Application for Removal or Variation of a Condition following Grant of Planning Permission or
Listed Building Consent

Part one/Part two storey side and rear extension and loft conversion with alterations to roofline to provide rooms in roofspace

22/01067/FUL
Reference: PP-11212895

project no. 7522	zone	type	classification [00]	drawing no. 200	revision 03
---------------------	------	------	------------------------	--------------------	----------------

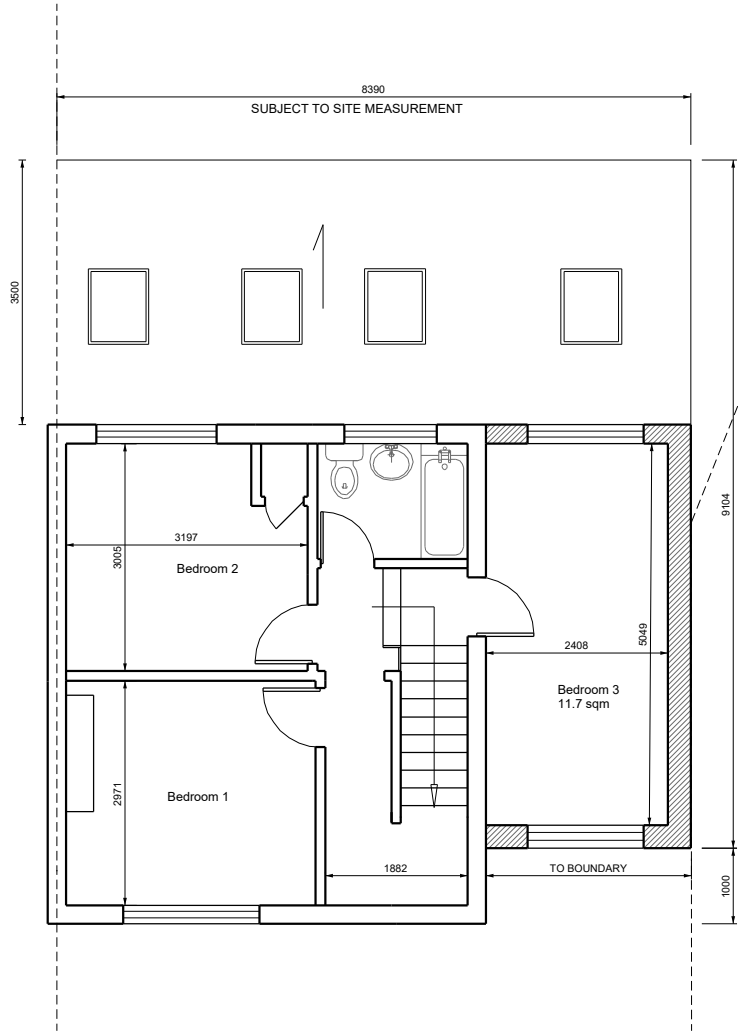
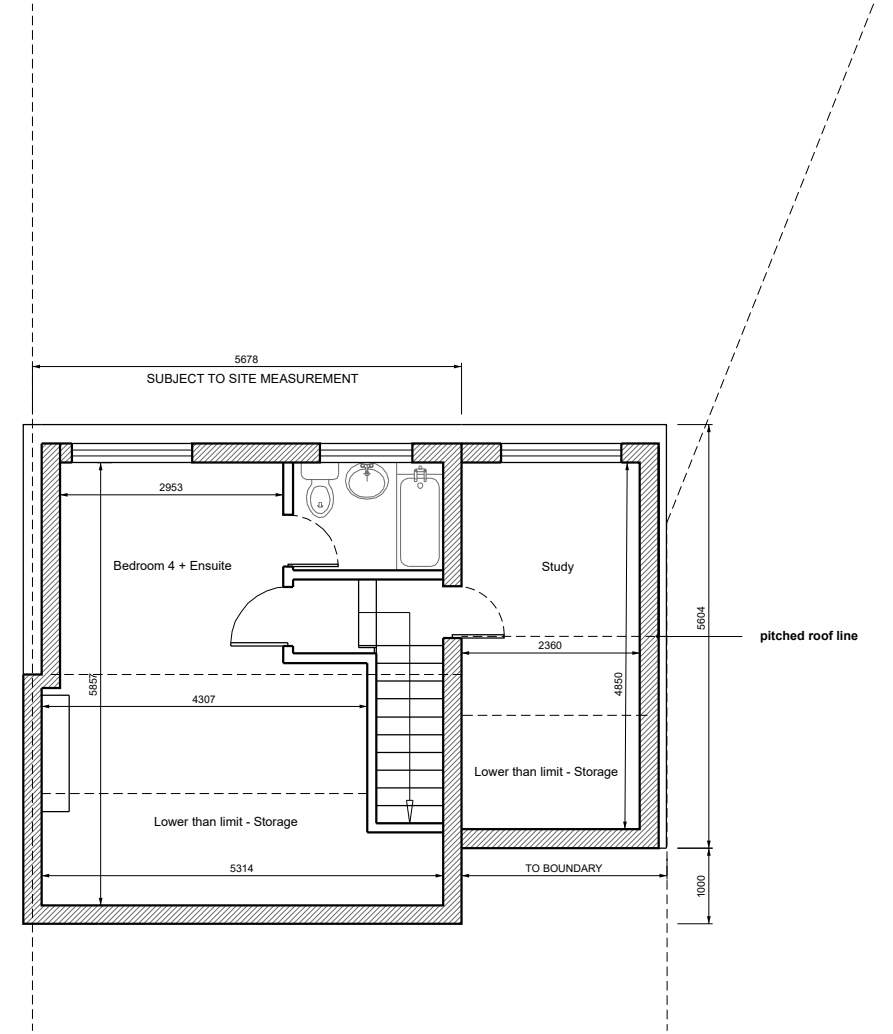
The variation is to convert the two-storey side extension roof type from hip into gable, with a rear dormer window, to match the approved gable roof type of the existing building, for the use of the current owners.

The variation is to convert the two-storey side extension roof type from hip into gable, with a rear dormer window, connecting to the approved rear dormer window behind the existing roof. All material to match existing.

We would like condition 2 to include the updated two-storey side extension roof type conversion drawings with the dimensions and materials as drawn, which would supersede the previous drawings 200_02, 210_02 and 201_03.
